10th July 2012

Application for Householder Planning Permission

Development Front in-fill extension between garage & lounge & alterations to roofline over garage & new extension. Conversion of garage to habitable space & replacement of rear conservatory with extension under Permitted Development
Location 9 Durham Close Bognor Regis

Existing GF Plan

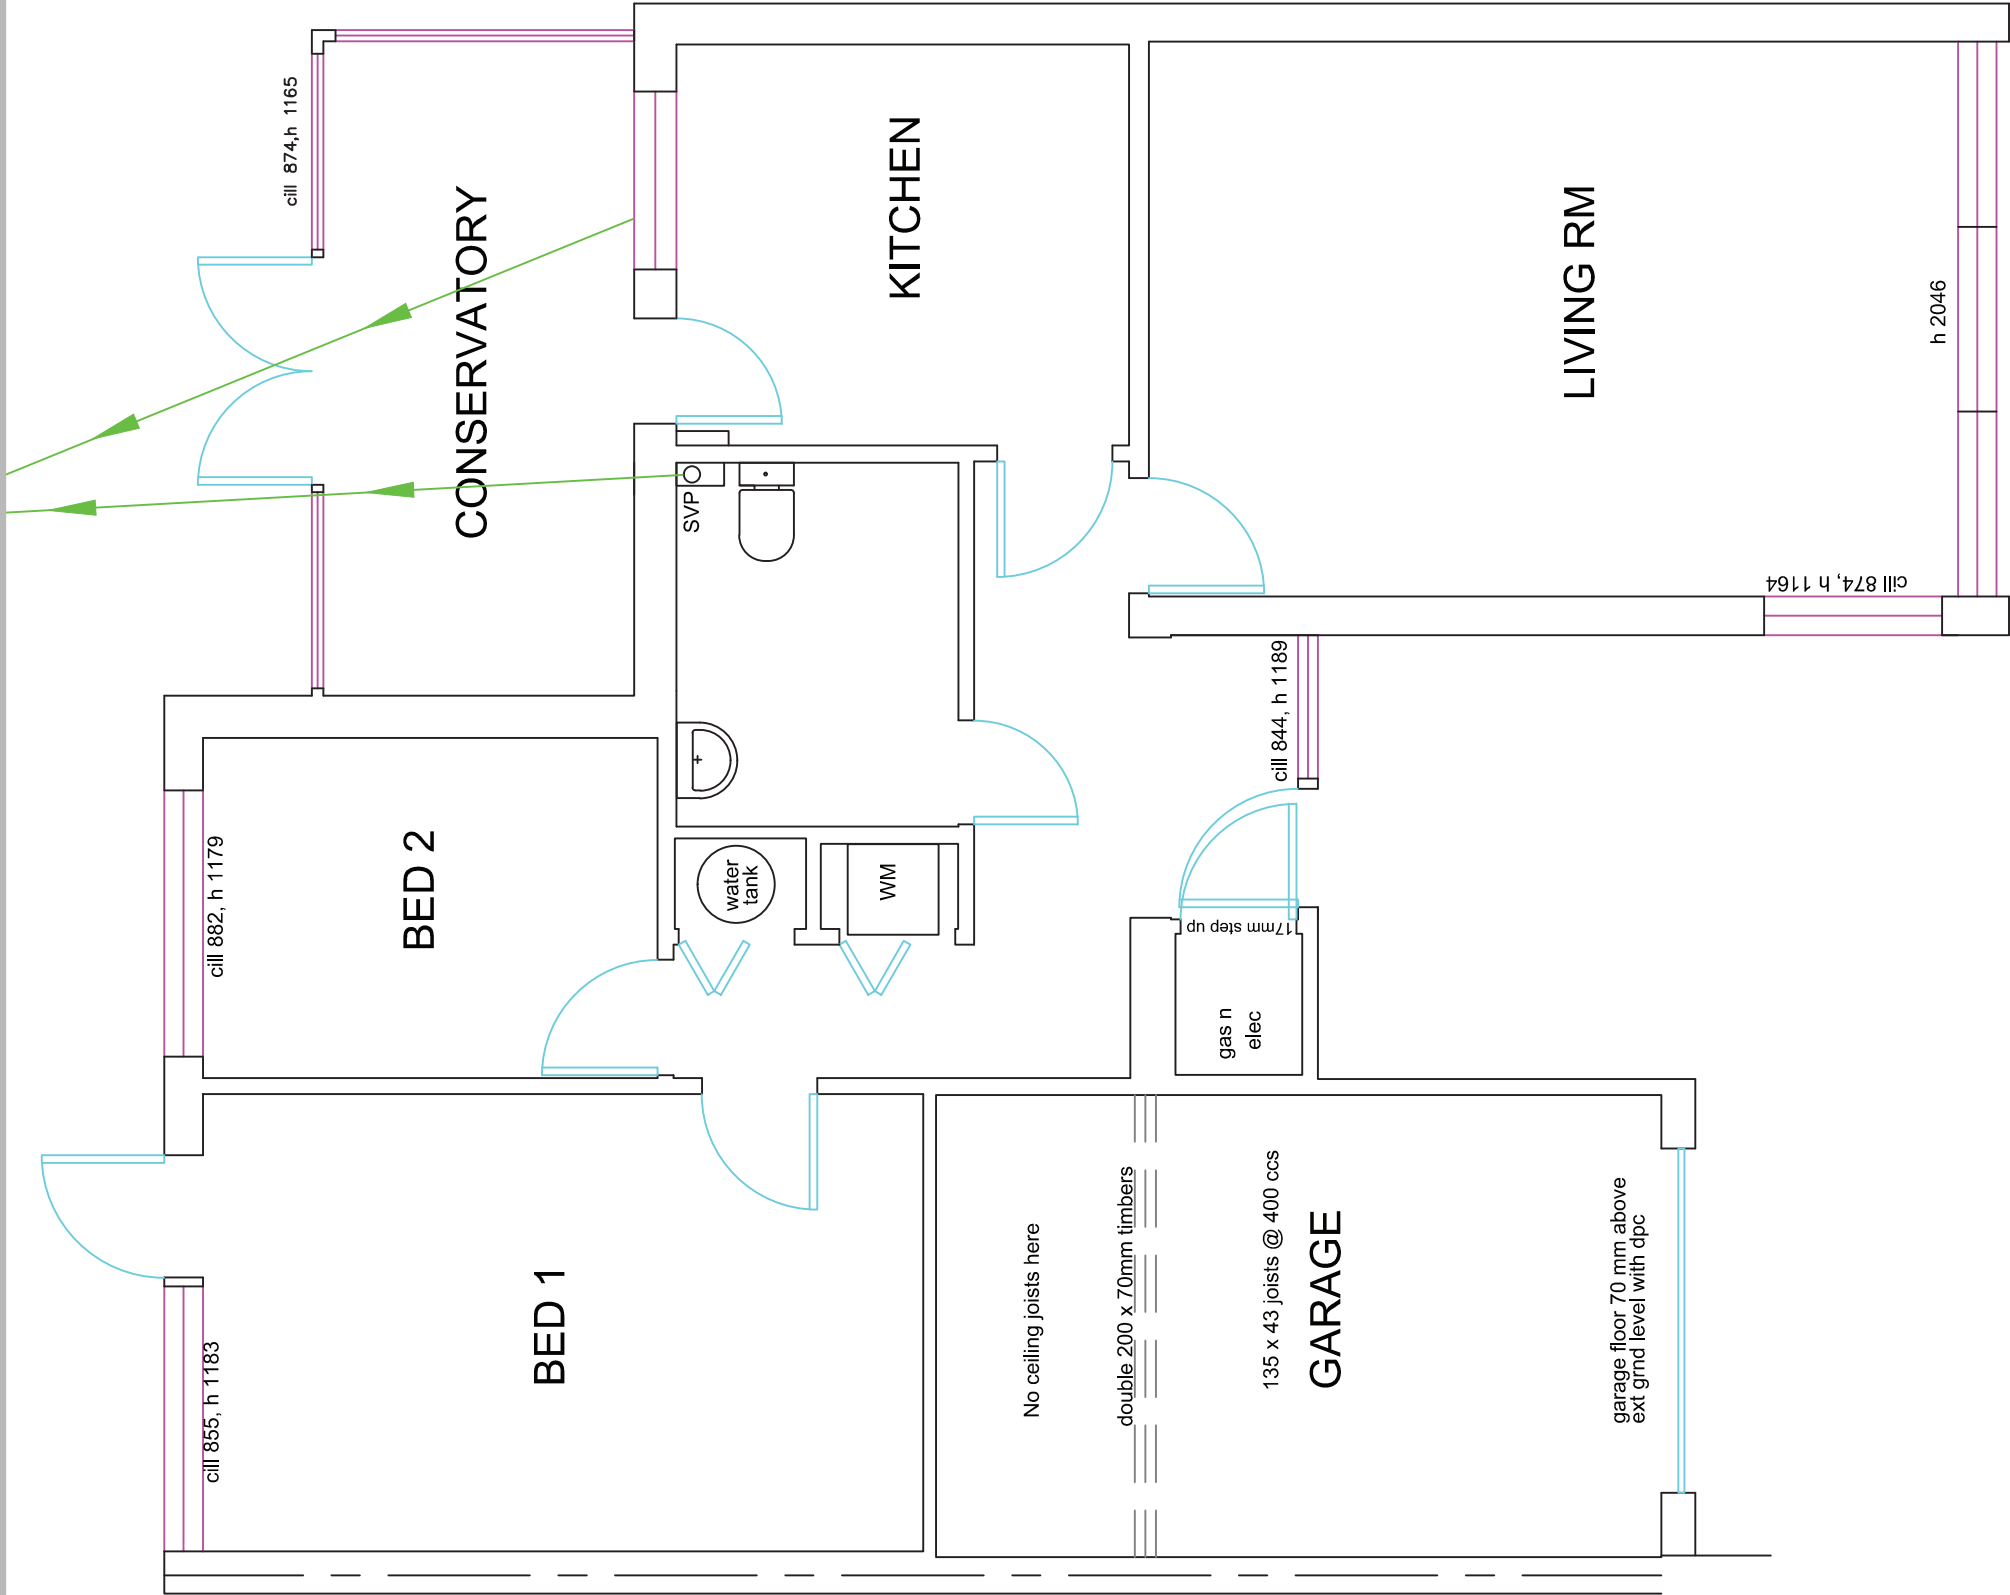
Please provide 1 electronic or 3 paper copies of a revised existing floor plan to show the garage door. ✓
